RE: SSD-11802230 SYDNEY OLYMPIC PARK NEW HIGH SCHOOL SSDA RESPONSE TO SUBMISSIONS ON TRAFFIC

Table 1 Response to submissions on traffic and Transport

NOTE:
1. REDUNDANT LINEMAKING, SIGNAGE AND ROAD SIDE FURNITURE TO BE REMOVED.

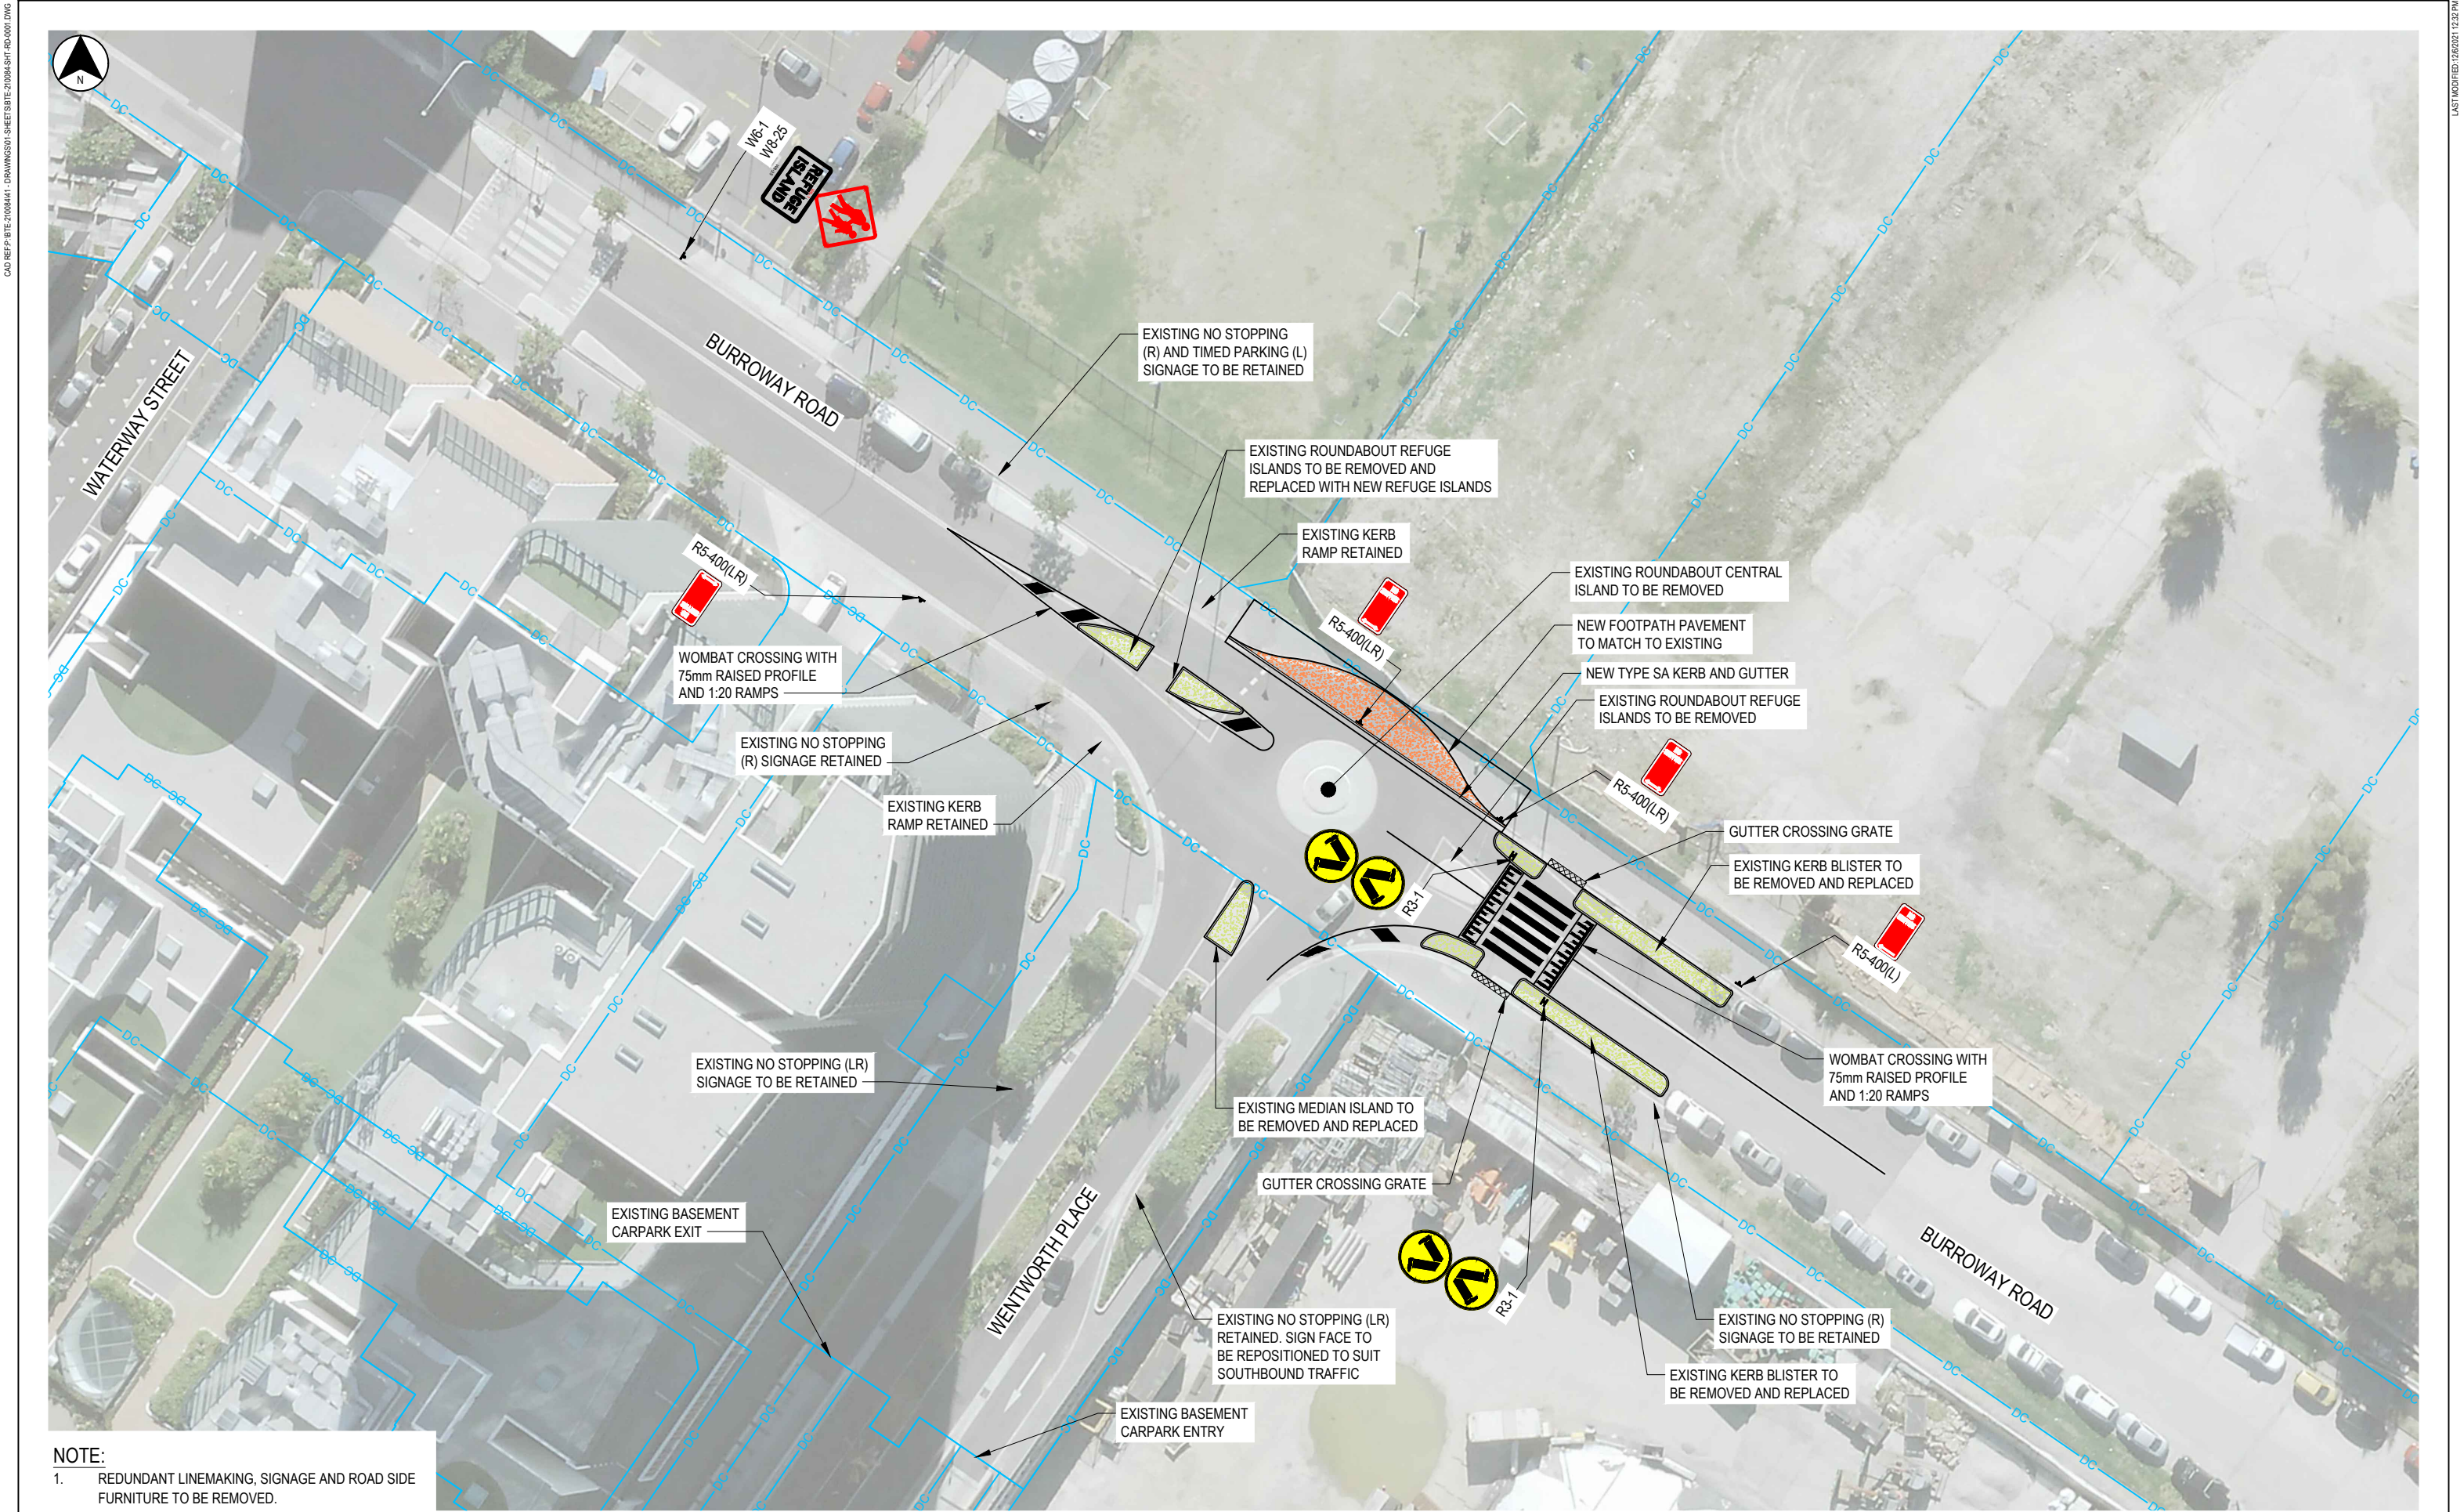
A 2.3	Demonstrate that the footpath width on Burroway Road adjacent to the roundabout and on site bicycle parking is sufficient to cater for the expected pedestrian demand and complies with relevant standards.	<p>SINSW is proposing to reconfigure the roundabout to a give way junction that will provide an increased footpath width at this location. The footpath width will exceed 1.2m width, so will meet accessibility standards.</p> <p>It is not possible to widen into the site given the constraints already present. The give way intersection was tested in SIDRA Network and the results indicated that the intersection can still perform at Level of Service A.</p> <p>While a roundabout provides some limited benefit for traffic to conduct U-turns, the give way intersection provides a higher quality crossing experience for students. The removal of the island and midblock islands makes for a more straightforward design of the proposed raised threshold zebra crossings, which are more challenging to install adjacent to a roundabout.</p> <p>The give way intersection has been incorporated into the revised landscape plan.</p> <p>The raised threshold zebra on the southern side of the intersection (on Wentworth Place south of Burroway Road) is not feasible to construct as there is insufficient sight distance to the exit ramp from Marina Square.</p>	Addendum

City of Parramatta submission letter dated 10 November 2021			
C 11.1	The previously envisaged road created a 4-way intersection with roundabout at Burroway Road and Wentworth Place. This intersection is now designed as a T-intersection roundabout with insufficient width along Burroway Road to provide a compliant footpath and nature strip. Additional space will need to be dedicated to Council so that an adequate footpath can be provided	<p>SINSW is proposing to reconfigure the roundabout to a give way junction that will provide an increased footpath width at this location. The footpath width will exceed 1.2m width, so will meet accessibility standards.</p> <p>There is no land dedication required.</p> <p>The raised threshold zebra on the southern side of the intersection (on Wentworth Place south of Burroway Road) is not feasible to construct as there is insufficient sight distance to the exit ramp from Marina Square. The provision of wider footpaths to the north as part of the give way intersection means this crossing is not required.</p>

SDRP 03 Advice Letter from Government Architect New South Wales dated 20 October 2021			
E 10	10. Footpath width – The footpath at the roundabout on Burroway Road is too narrow and poses a safety risk. Confirm resolution of this area to enable shared access for cyclists and pedestrians during peak periods.	<p>SINSW is proposing to reconfigure the roundabout to a give way junction that will provide an increased footpath width at this location. The footpath will be of the same width as the remaining Burroway Road and therefore be able to continue the shared path along the frontage of the site.</p> <p>The space will have adequate room for pedestrians and cyclists.</p>	Additional information

Our ref	Submission	Response	Type
		The raised threshold zebra on the southern side of the intersection (on Wentworth Place south of Burroway Road) is not feasible to construct as there is insufficient sight distance to the exit ramp from Marina Square. The provision of wider footpaths to the north as part of the give way intersection means this crossing is not required.	
Public Submissions Themes			
F 1	Transport Capacity	<p>The school is also located such that walking and cycling are feasible and realistic options for students in the catchment. Hence the primary means of mitigating impacts to the community is the location of the school - a short walk for apartments and public transport options.</p> <p>A funded transport coordinator is proposed to deliver programs that encourage students to walk and cycle to school. Sufficient bicycle and scooter parking capacity have been provided to enable a large take-up of cycling.</p> <p>Traffic modelling undertaken shows that the intersection performance impacts of the school are at an acceptable level - being less than Level of Service D.</p>	Additional information
